Our Reference: SYD12/00829
Your Reference: MP11_0090
Contact: Xi Lin
Telephone: 8849 2906

Transport
Roads & Maritime
Services

**ENVIRONMENTAL ASSESSMENT (EA) EXHIBITION
STUDENT ACCOMMODATION ON BLOCKS 3B,3C&10, AT CENTRAL PARK,
CHIPPENDALE(FORMER CARLTON UNITED BREWERY SITE)(MP11_0090)**

DRAWING NO A-202	REVISION

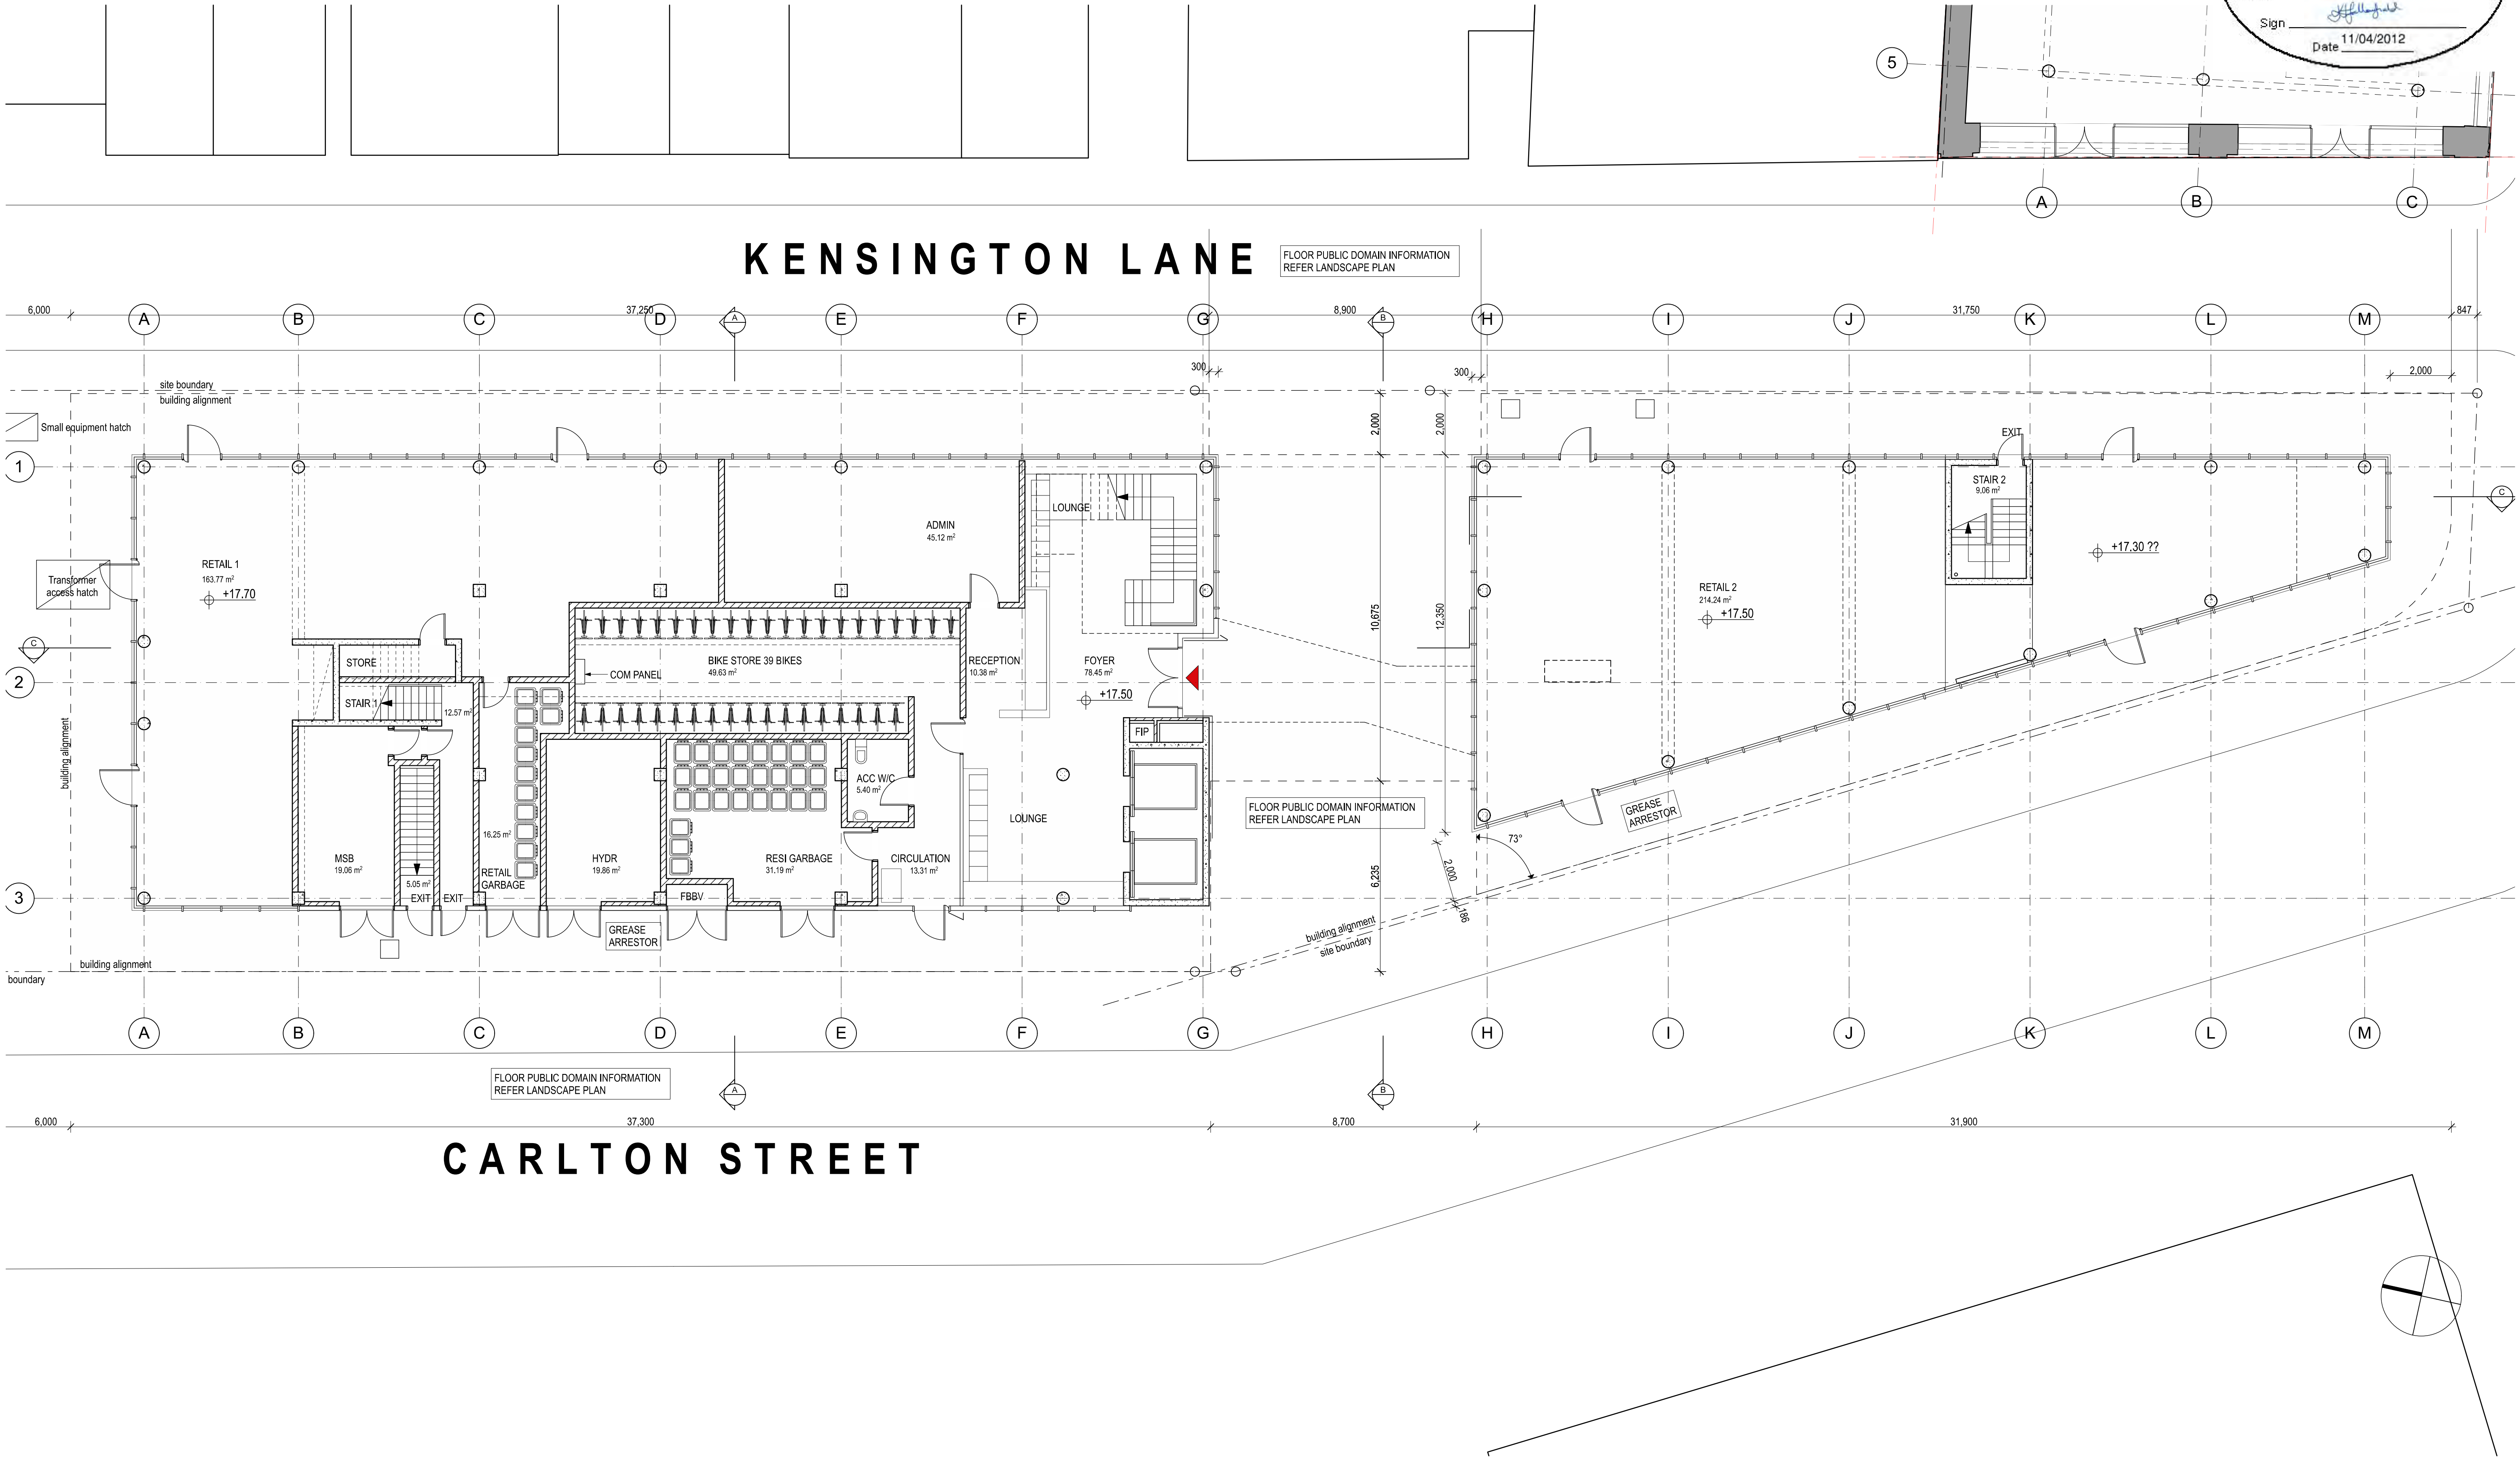
1. The layout of the proposed car parking areas, loading docks and access driveway associated with the subject development (including, driveways, grades, turn paths, sight distance requirements, aisle widths, aisle lengths, and parking bay dimensions) should be in accordance with AS 2890.1- 2004 and AS 2890.2 – 2002 for heavy vehicle usage.
2. The required sight lines to pedestrians or other vehicles in or around the carpark or entrances are not to be compromised by landscaping, signage, fencing or display materials.
